Application number: 2026/90666	
What is the application for?:	Rear landscaping and erection of retaining walls to the rear and side boundaries
Address of the site or building:	Sunnyside, 56, Heaton Road, Paddock, Huddersfield, HD1 4HZ
Postcode:	HD1 4HZ

DRAWING NUMBER: 26/4138/A3

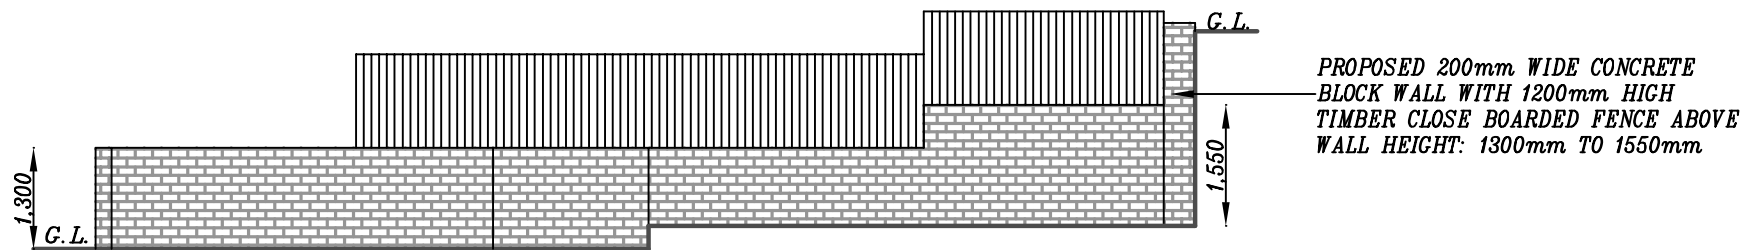
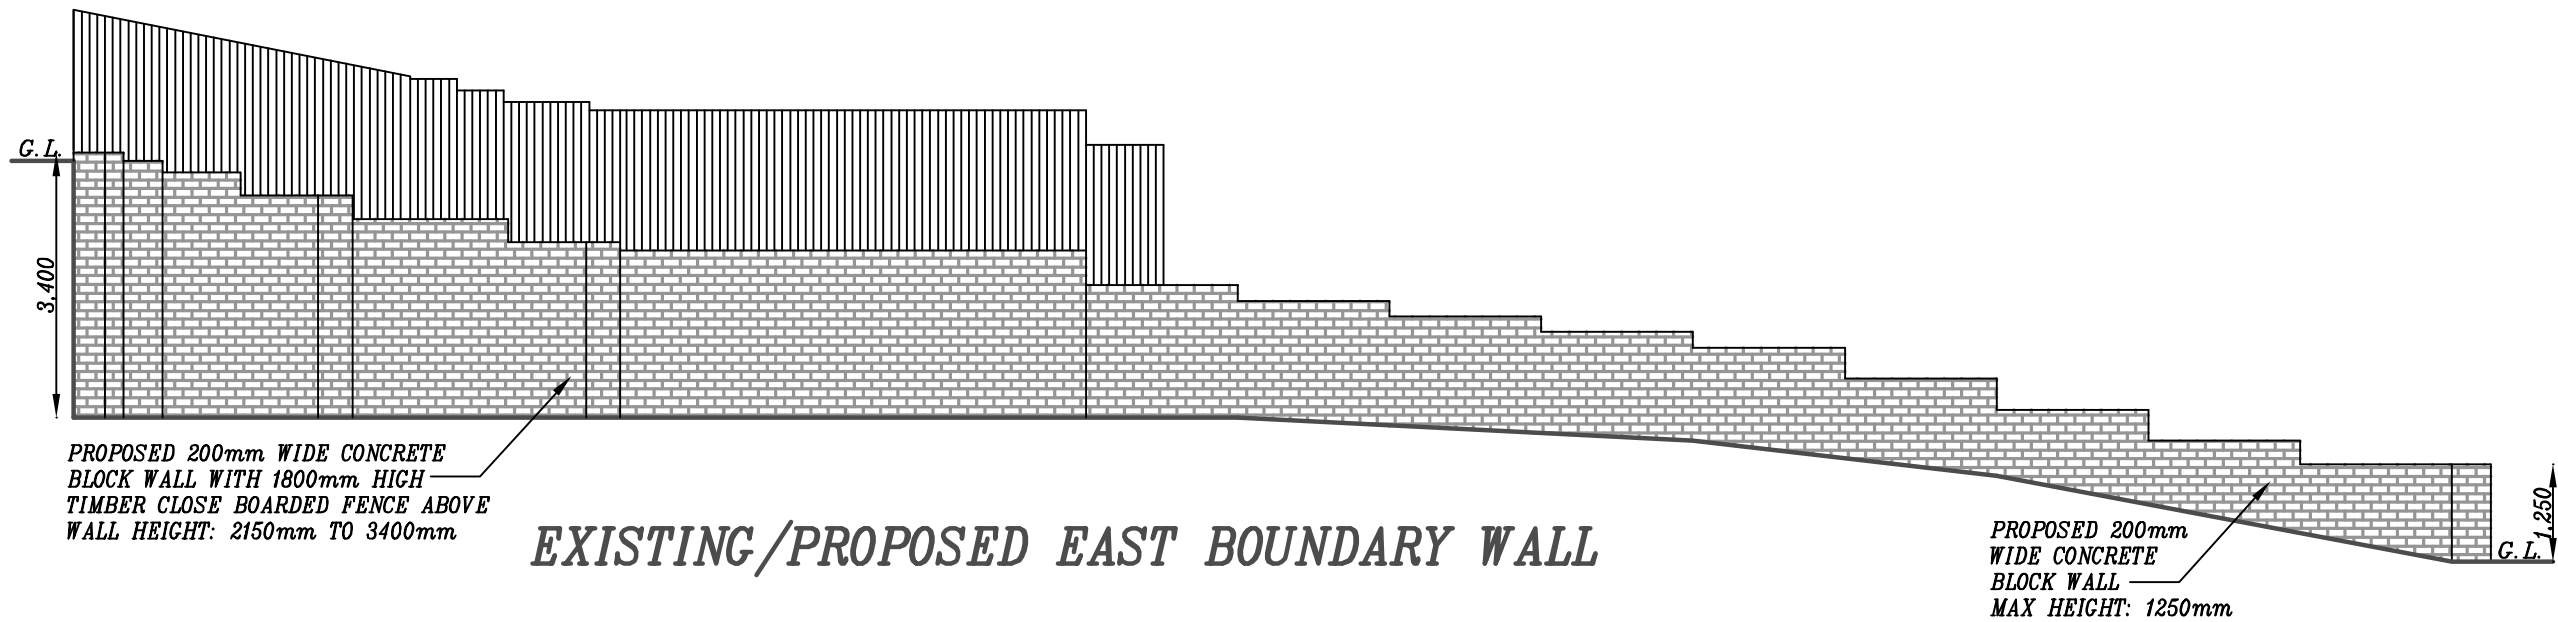
Type of comment: A general comment	
Do you wish your comments to be published on the website anonymously?	Yes
<p>If standing on Heaton Rd looking at 56 Heaton Rd, property is to the right of no. 56. The retaining wall built to the rear garden at no. 56 is to the left of rear garden. This retaining wall has been built lower than the level of rear garden & therefore causing ground movement. land has slipped.</p> <p>greenhouse in rear garden and is located in the top left corner. greenhouse has been in this location for over 10 years with no previous issues. The base to greenhouse is masonry and the bricks have moved causing greenhouse to move. greenhouse is now on unstable ground and has moved.</p> <p>photos should you require.</p> <p>The height of the retaining wall built needs to be increased so it is level with the ground level of rear garden and the gap between the retaining wall and land needs to be back-filled & compacted with topsoil so it is the same height as land. This is required to stop further movement of land and further damage. said to the applicant previously this remedial works needs to occur & invited into back garden to view in person so it is disappointing the planning application makes no mention of the aforementioned works to stop further ground movement.</p>
